KIRKLEES METROPOLITAN COUNCIL INVESTMENT & REGENERATION SERVICE

DELEGATED DECISION TO DETERMINE PLANNING APPLICATIONS

Reference No:	2023/62/93116/W
Site Address:	17, Goldington Avenue, Oakes, Huddersfield, HD3 3PU
Description:	Erection of two storey side extension
Recommending Officer:	Laura Yeadon

HOUSEHOLDER DELEGATED REPORT

Proposed side/north east facing elevation (1:100)

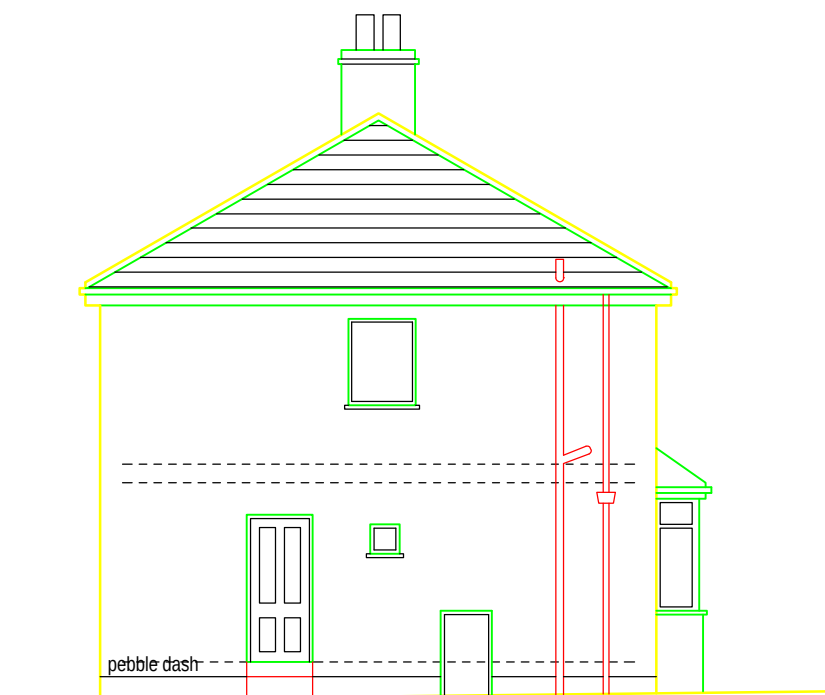
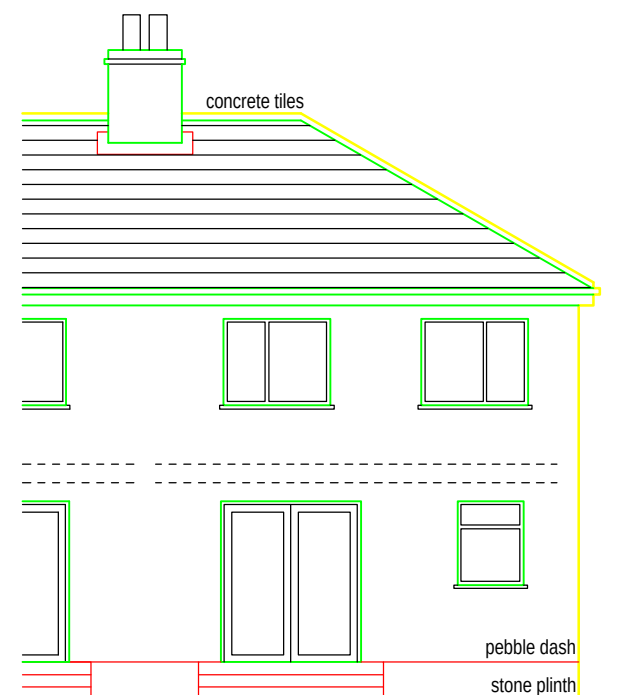
The proposed two storey extension would be located on the side elevation of the property, set back from the front elevation of the property by ~2.3 metres and would project to the side by 1.8 metres. The extension would align with the rear elevation of the original dwelling. The eaves height would match the existing with hipped roof line being set down from the existing roof ridge by ~0.8 metres.

Not take up all or most of the space to the side of a house	Yes – the extension is set in from the side boundary of the property	
maintain a 1 metre gap to the side boundary to ensure the building is not too close to a neighbouring property		No – a 1 metre gap is not retained between the side boundary and the extension, however is set in by ~0.5 metres and the neighbouring property set in from the shared boundary by approx. 2.4 metres ensuring a sense of space is retained between the dwellings
be set back at least 500mm from the front wall of the house	Yes – the extension is set back from the front elevation of the property by more than 500mm

Existing block plan (1:500)

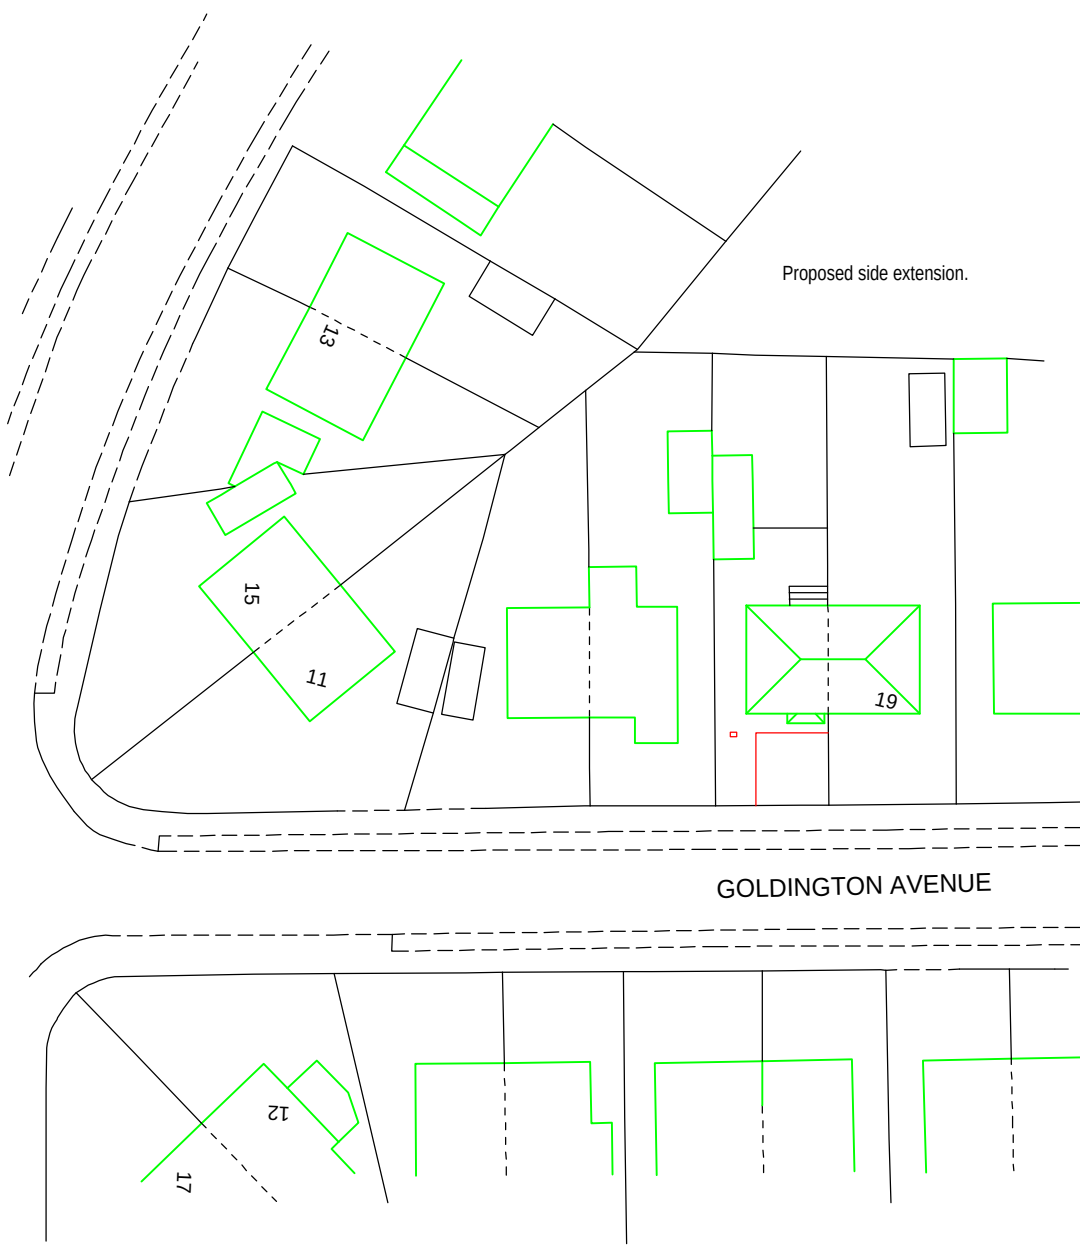
It is also proposed that part of the dwarf wall to the front of the property would be removed and driveway widened to allow for 2 no. parking spaces. The width of the drive would be increased from 2.5 metres to 4.4 metres and finished in tarmac. 1.5 metre width of dwarf wall would be removed to facilitate the parking area.

widened to allow for an additional parking space. A condition can be attached ensuring that the extended parking area is permeable.	
Provision for waste storage	• KDP 16 of the SPD • Policy LP24 Design (d) (iv) • Chapter 12 of the NPPF	None shown on plan however sufficient space within the site boundary to accommodate bin storage	✓

4. The development shall not be brought into use until all areas indicated to be used for parking on the submitted/listed plans have been laid out with a hardened and drained surface in accordance with the Communities and Local Government; and Environment Agency's 'Guidance on the permeable surfacing of front gardens (parking areas)' published 13th May 2009 (ISBN 9781409804864) as amended or any successor guidance. Notwithstanding the provisions of the Town and Country Planning (General Permitted Development) (England) Order 2015 as amended (or any Order revoking or re-enacting that Order) these areas shall be so retained, free of obstructions and available for the use specified on the submitted/listed plans for the lifetime of the development.
